| Application Ref: | 3/2025/0288 | | |  Ribble Valley Borough Council www.ribblevalley.gov.uk |
| DELEGATED ITEM FILE REPORT: | | | | APPROVAL |

| Development Description: | Proposed detached garden room to rear and changes to land levels. |
| Site Address/Location: | 2 Northcote Park, Langho, BB6 8FB. |

Proposed Site Plan

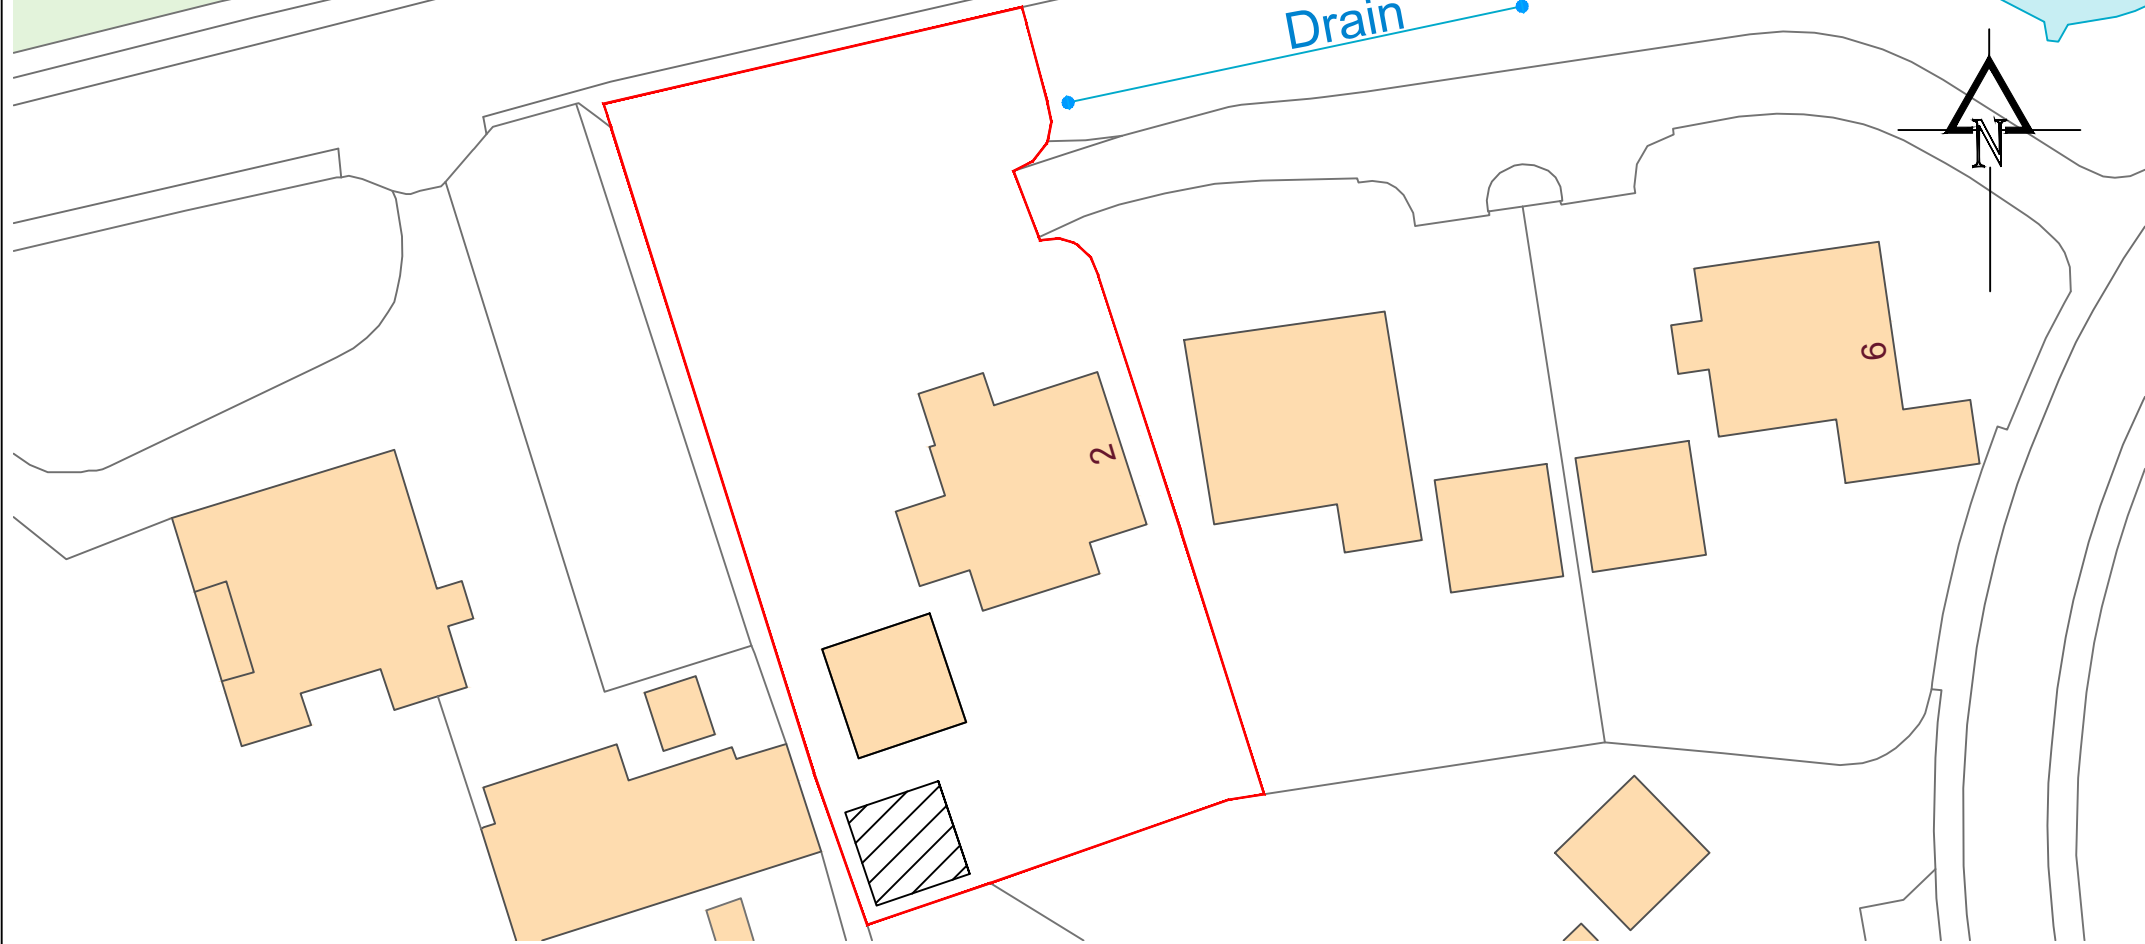
As part of the overall development, the land level of the property's rear garden area is also proposed to be reduced by a maximum of 1.2m.

Revision	Description
Location	
Mr S. Woodward	2 Northcote Park Langho Blackburn, Lancashire BB6 8FB
Title	
Scale	Proposed Plans and Elevations
As indicated @A1	Drawing No. 25001 P03
	Revision

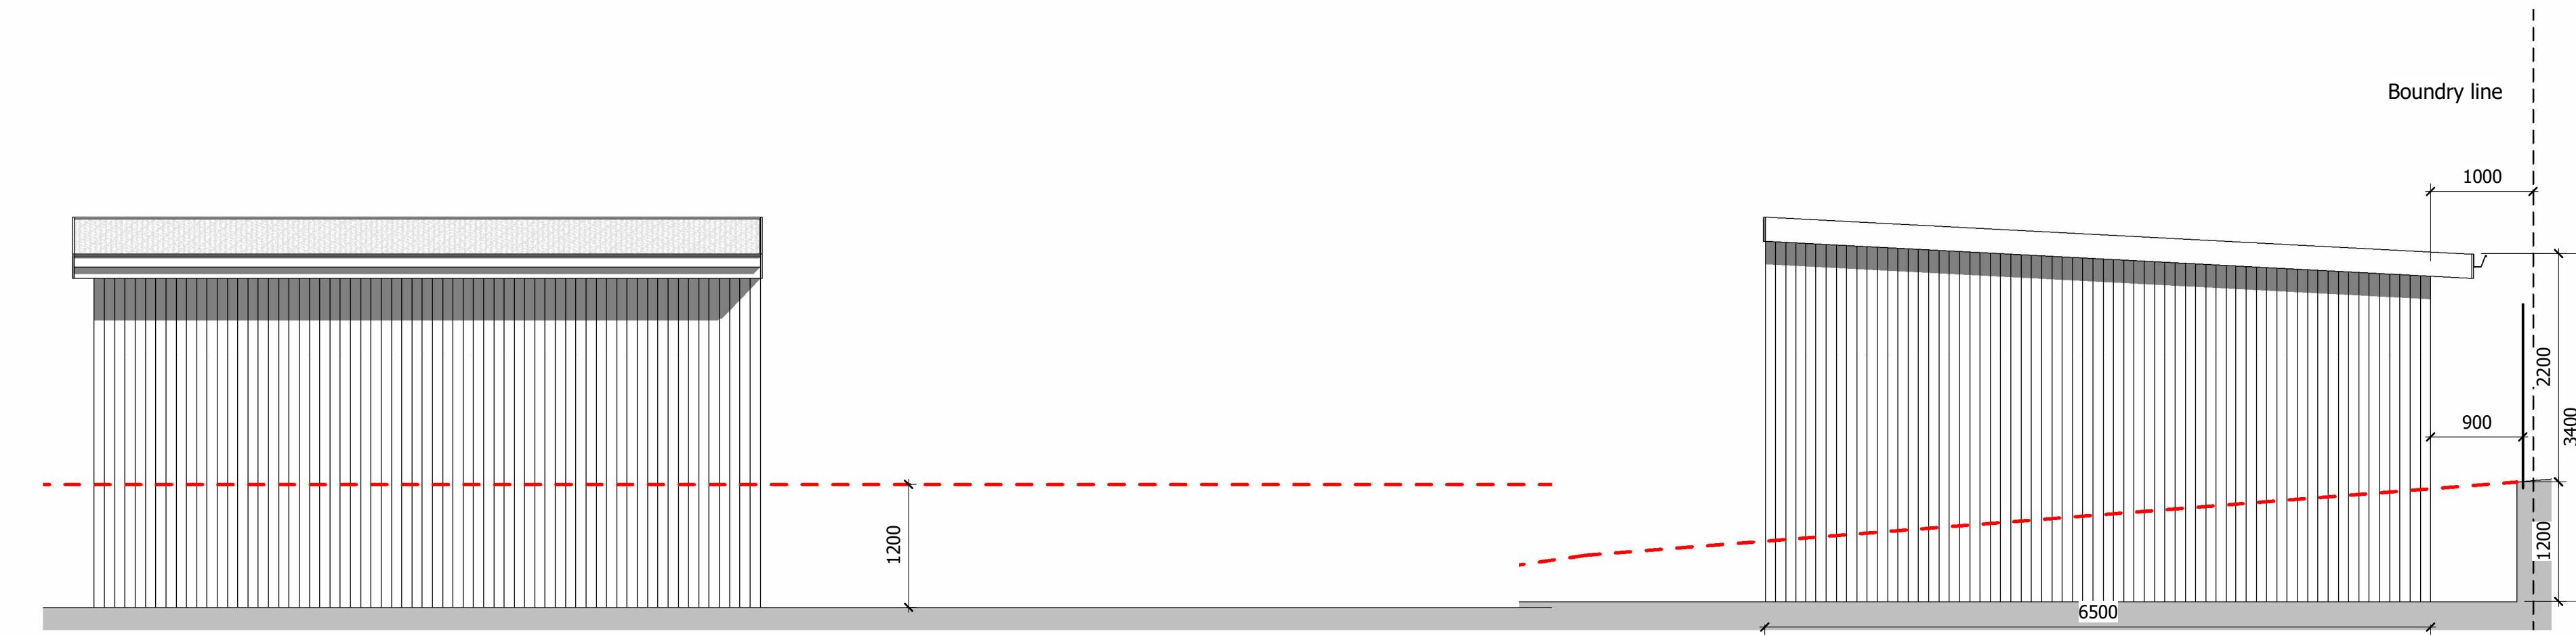
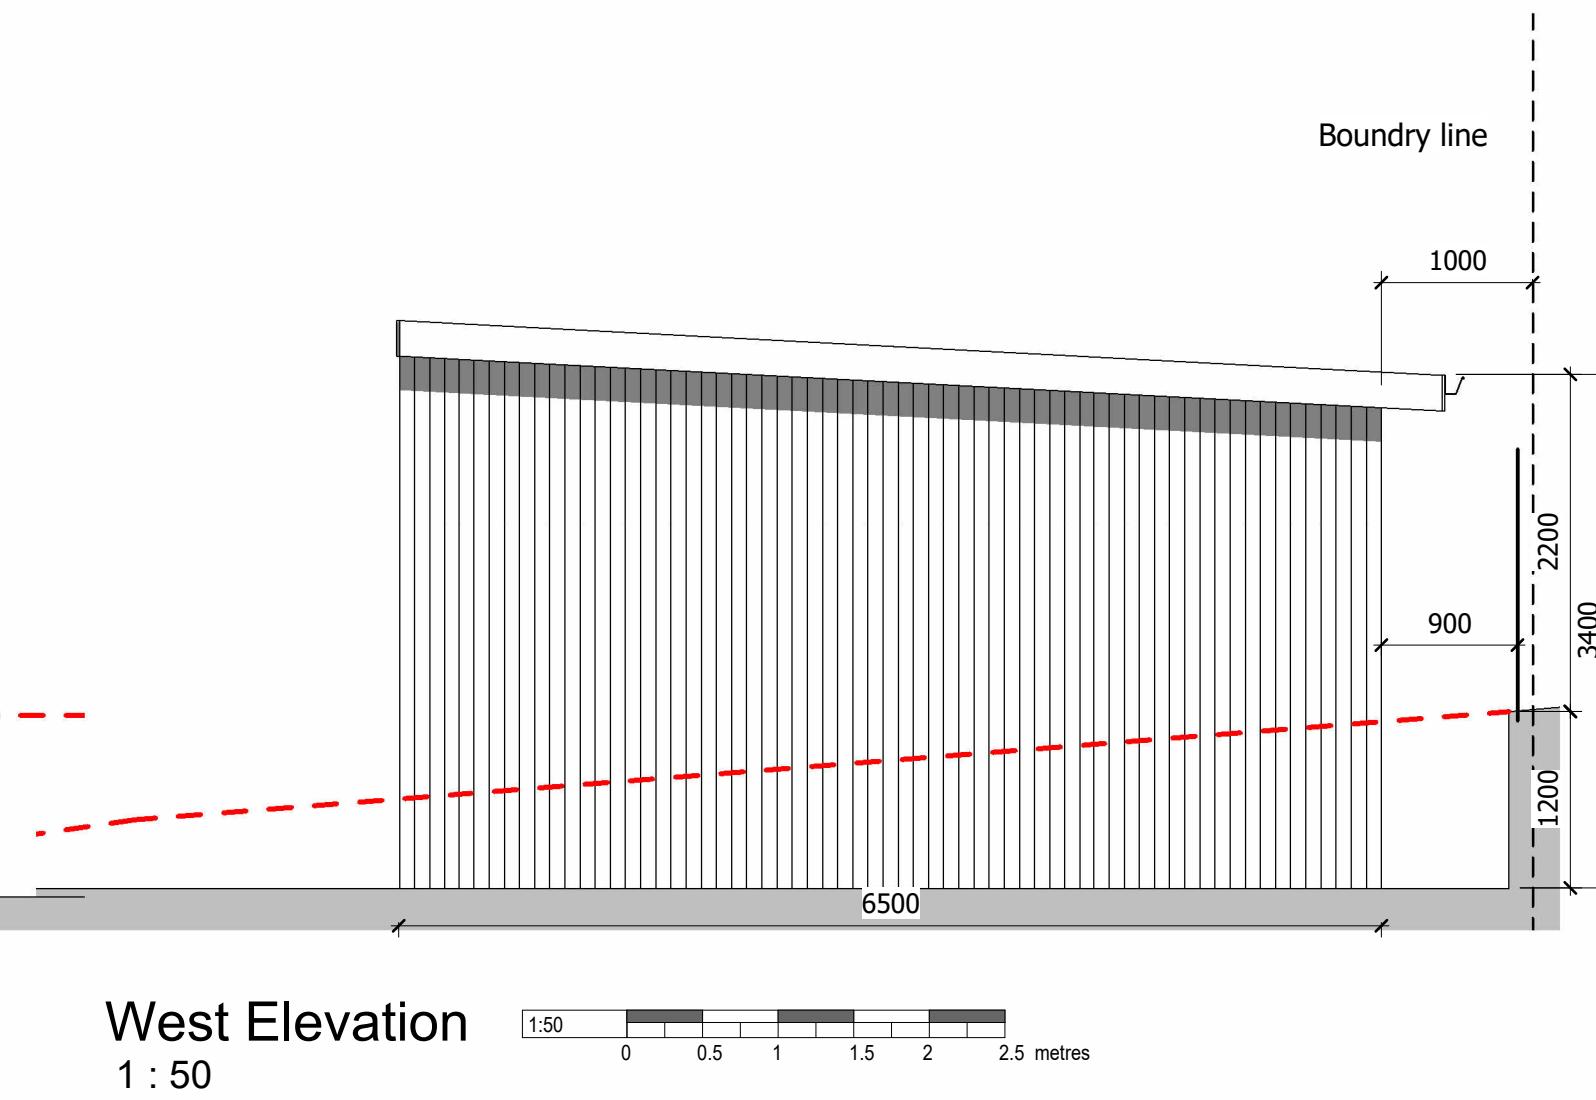
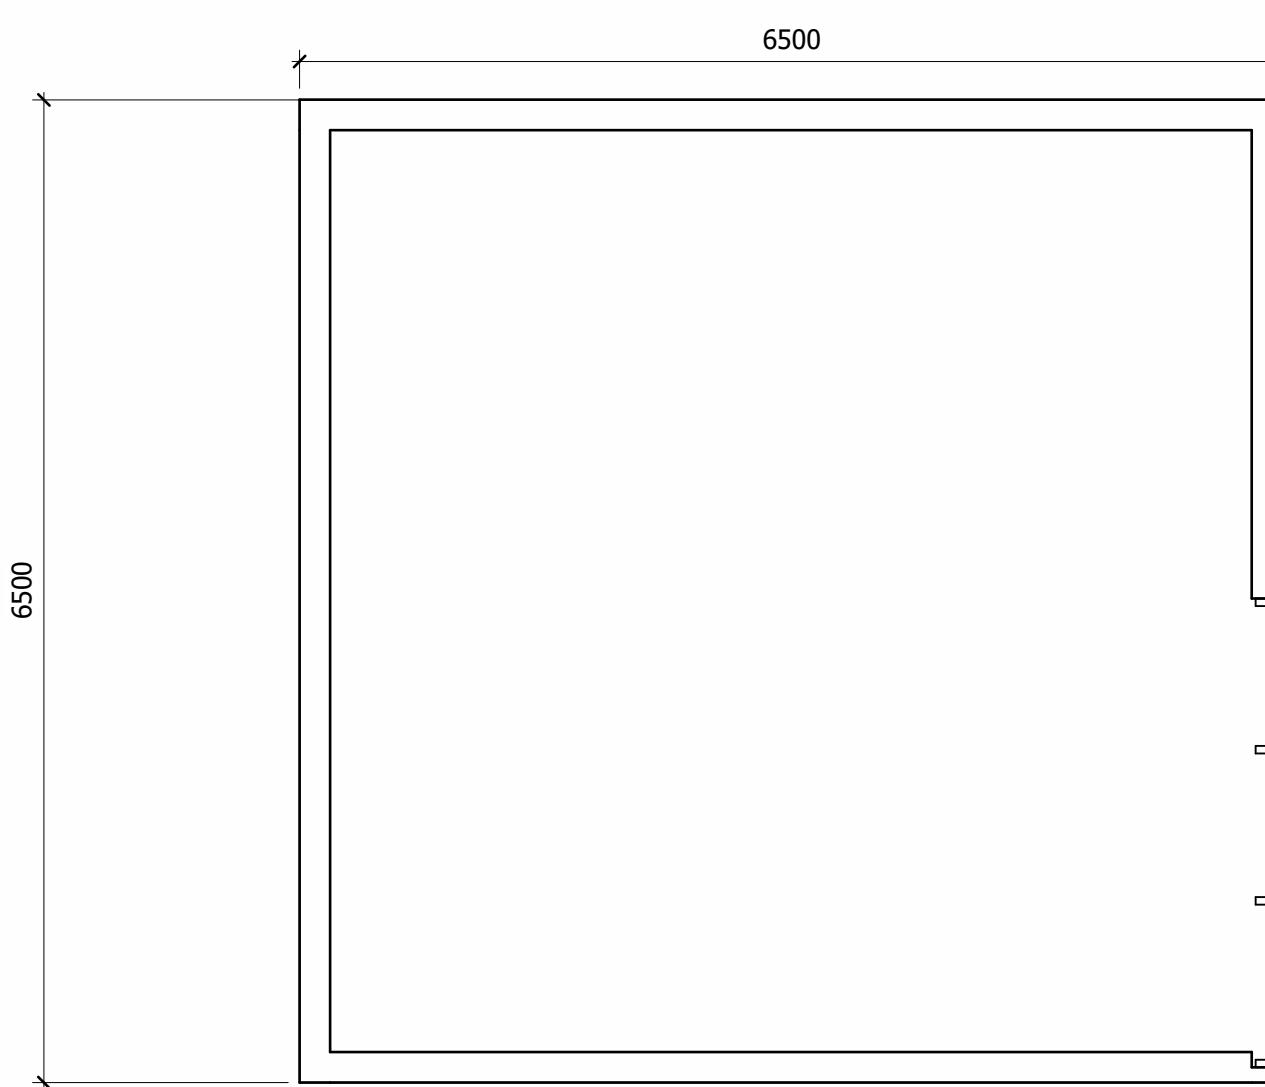
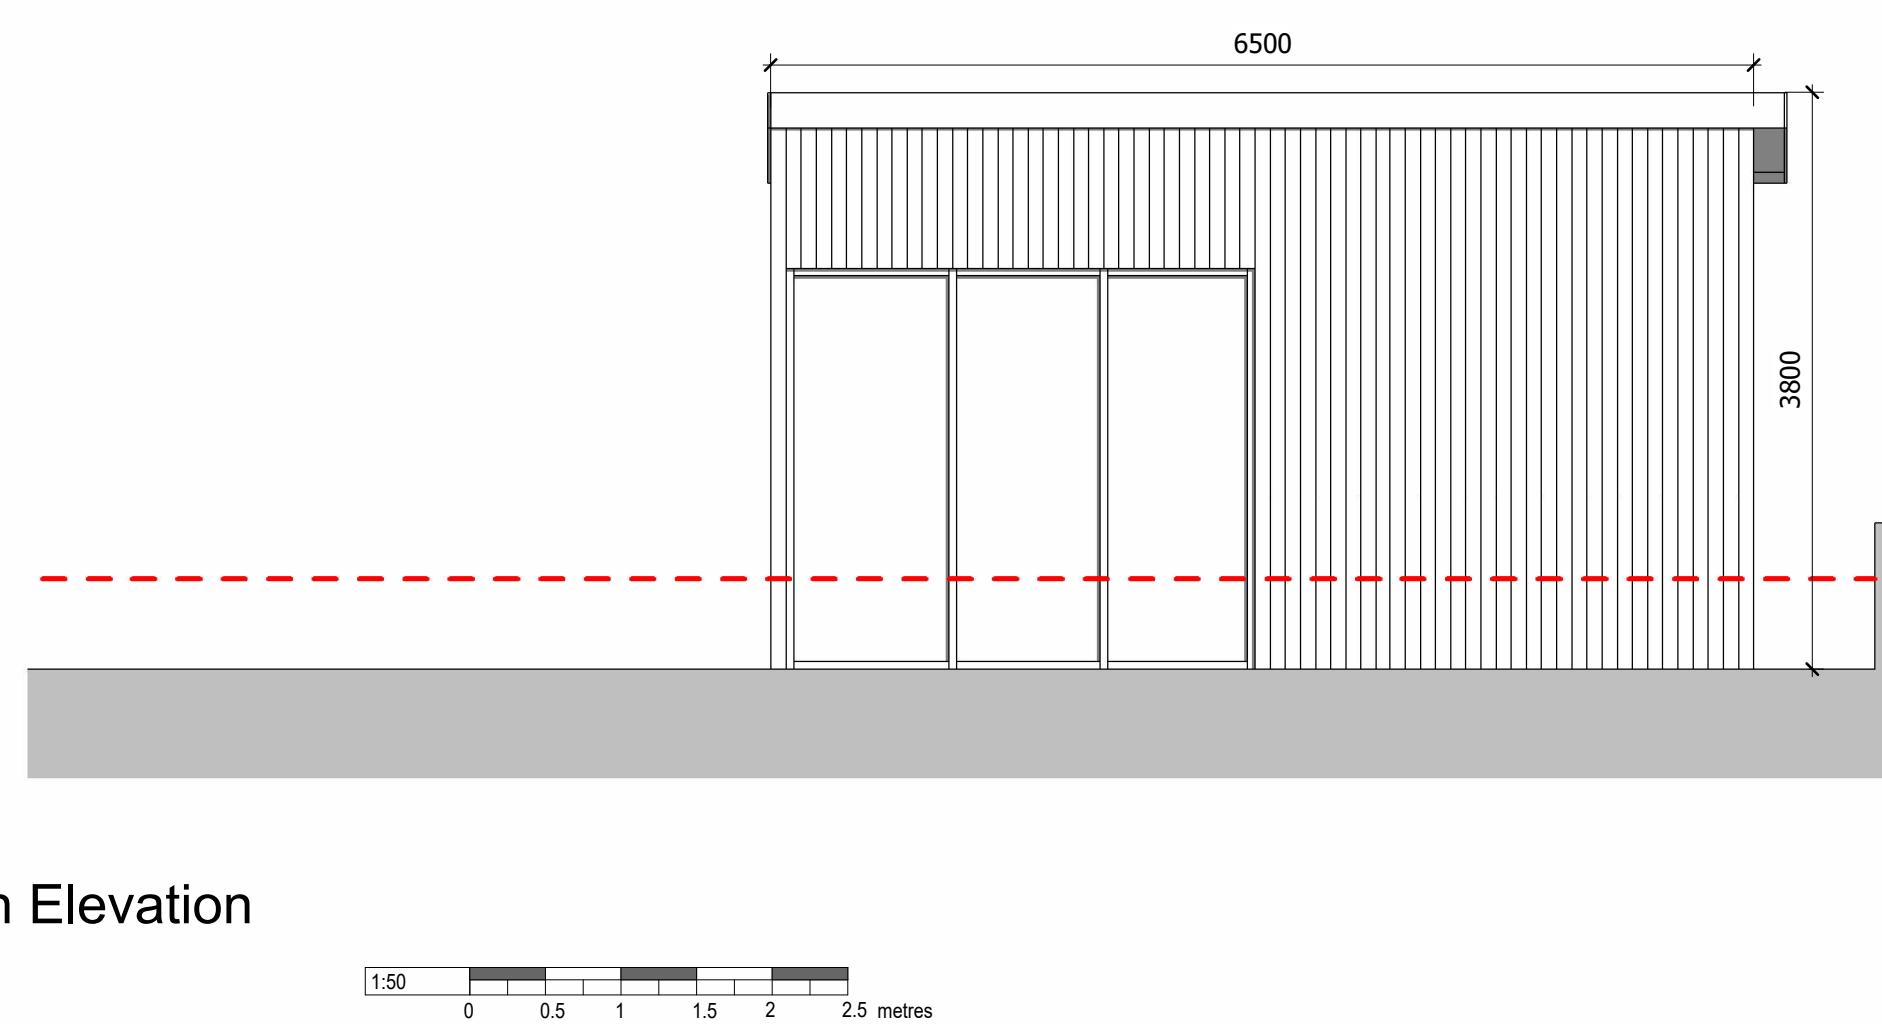
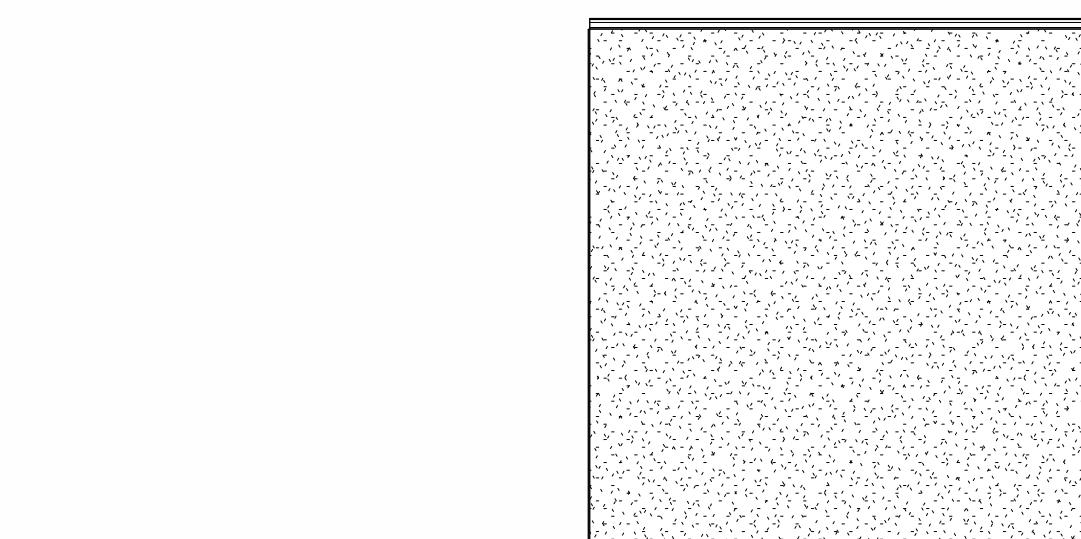
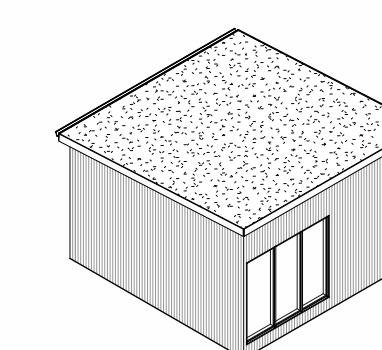
The original scheme comprised a sizeable, detached outbuilding measuring 13.5m by 6.5m with a maximum height of 3.8m. However, the structure was considered overtly large and excessive for a detached incidental outbuilding, insofar that the size and scale of the proposed building would not be visually reflective of its secondary nature to that of the domestic functions of the host property.

Following discussions with the applicant, the footprint of the building has been reduced to measure 6.5m by 6.5m. While the 3.8m height remains, it is understood the structure would primarily serve as a golf simulator which necessitates the height proposed in order to provide enough space for the swing of a golf club. Taking account of the intended use of the building and given the proposal would not be afforded a high level of visibility from the adjacent public realm being visually screened by the property's existing detached double garage, the proposed amendments are considered sufficient to address the aforementioned concerns. The proposed materiality of the building and land level changes are also considered acceptable in this particular instance.
